A47 North Tuddenham to Easton

Scheme Number: TR010038

Volume 9 **9.27 Applicant's Responses to Deadline 6** **Comments**

January 2022

SECTION C - 'C' OVERVIEW
SCALE 1 : NTS

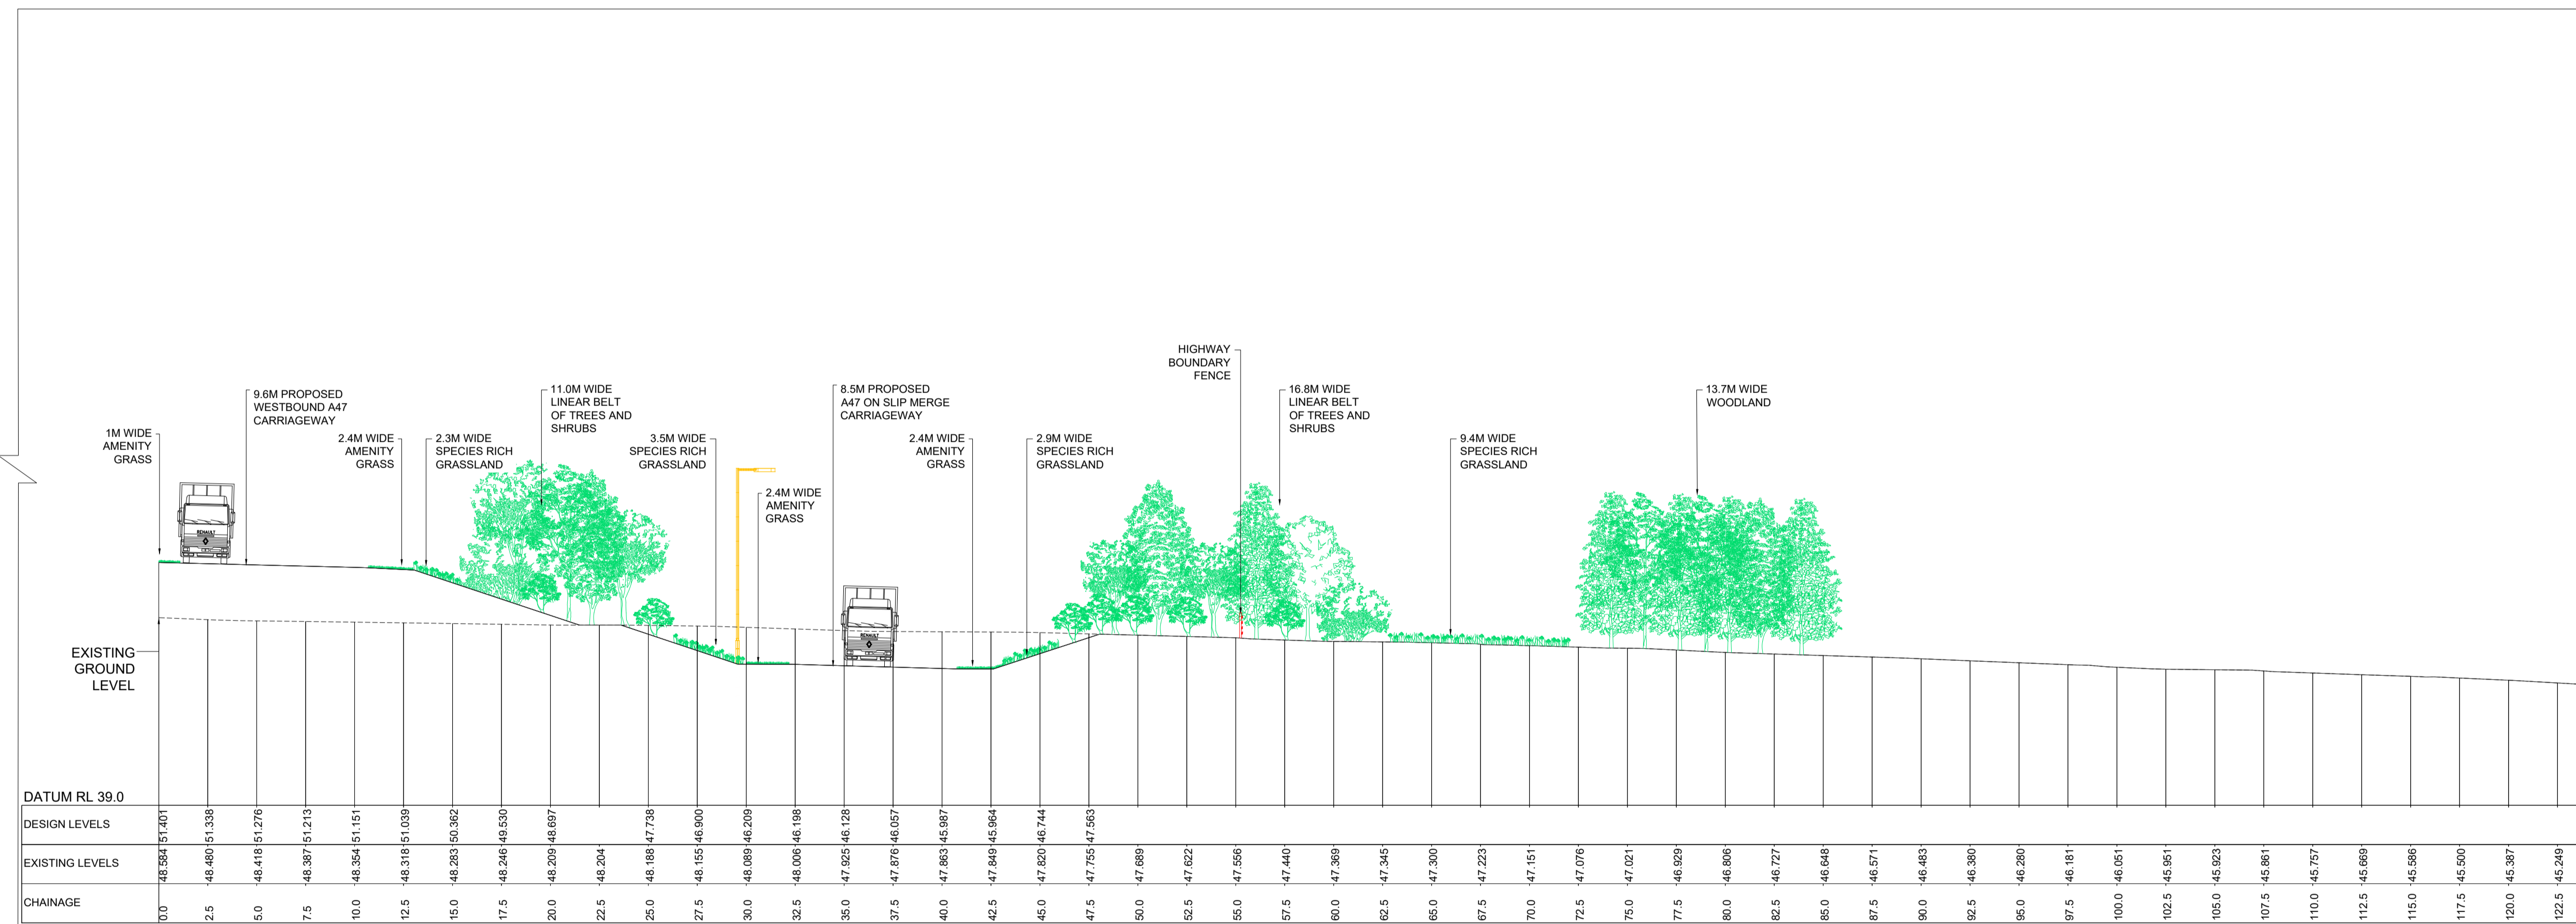
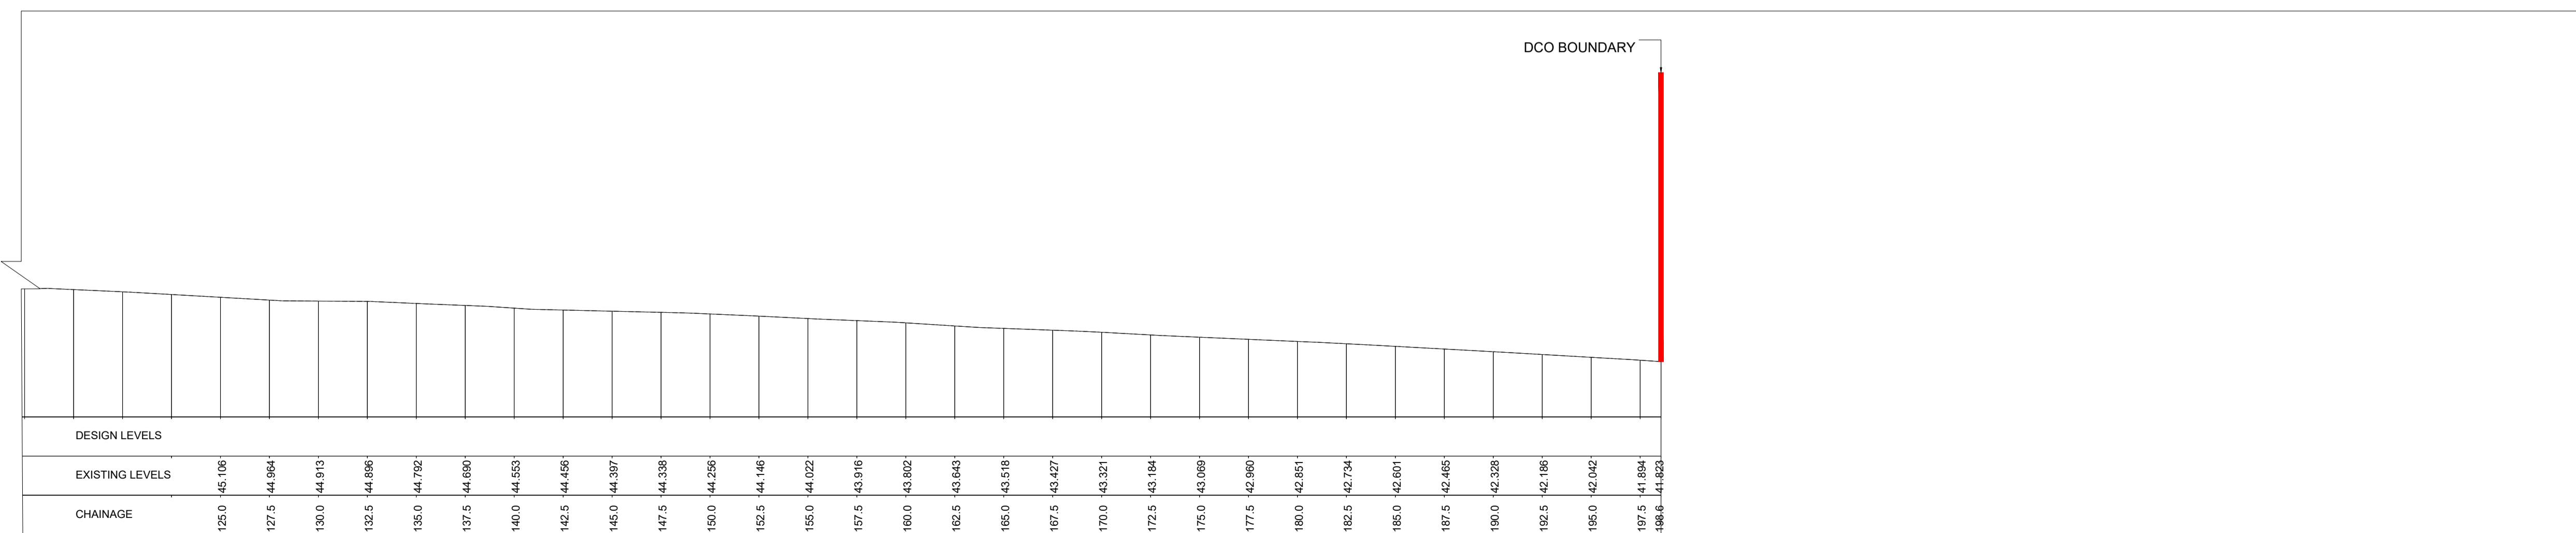
| Comment | Applicant Response |
|--|---|
| <p>5. Heritage. HE is keen to state that the new road will be moved over 200 metres south of the existing A47 and away from properties near St Andrew's Church and the Taverham Road properties. The truth of the statement is actually that whilst the main road itself will be moved away that distance, the new junction to the north and its access roads are only half that distance further south and, crucially, they are being moved into a more direct visual proximity (vertically as well) with the residential properties. Noted that the second plan extract in the HE response did not include the residents that will be almost on axis with the junction.</p> | <p>006).</p> <p>While the mainline is 200m further south of the existing A467, the slip road in between is approximately 115m further south.</p> <p>However, the existing A47 and Taverham Road junction is located approximately 65m south of the River Tud bridge, whilst the northern side of the proposed new junction's northern roundabout is approximately 220m south-west of the River Tud bridge. Most residential properties on Taverham Road lie north of the Taverham Road's River Tud bridge, thus approximately 155m further from the new junction.</p> <p>In addition, as reported in the 'Applicant's Responses to Deadline 4 Comments' (REP5-016), cross sections were provided for the affected properties along Taverham Road. Visual effects identified in Year 15 on properties along Taverham Road are:</p> <ul style="list-style-type: none"> • Neutral adverse (no significant) visual effect on 3 properties at Church Farm (Visual Receptors at R33), on the west side of Taverham Road. • Moderate adverse (significant) effect on views from Viewpoint 7 and from four properties on the east side of Taverham Road opposite Church Plantation (Visual Receptors at R34) during construction and in Year 1 of opening. However, this reduces to slight adverse (not significant) at Year 15 of operation following establishment of mitigation planting beside the Scheme (including tree cover beside the drainage feature directly to the south of the receptor) limiting the visibility to at most glimpsed views. <p>Effects on specific visual receptors are assessed in ES Appendix 7.4 'Visual Receptors' (APP-092) and summarised on Figure 7.5, Rev. 1 (REP2-012).</p> <p>Sheet 14 of the Environmental Masterplan, Rev 2, (REP3-016) demonstrates provision of woodland and shrub planting north of Norwich Road Junction to supplement the retained mature trees north of the existing A47, as shown below, provide a visual screen to properties near Honingham Church and along Taverham Road.</p>  |
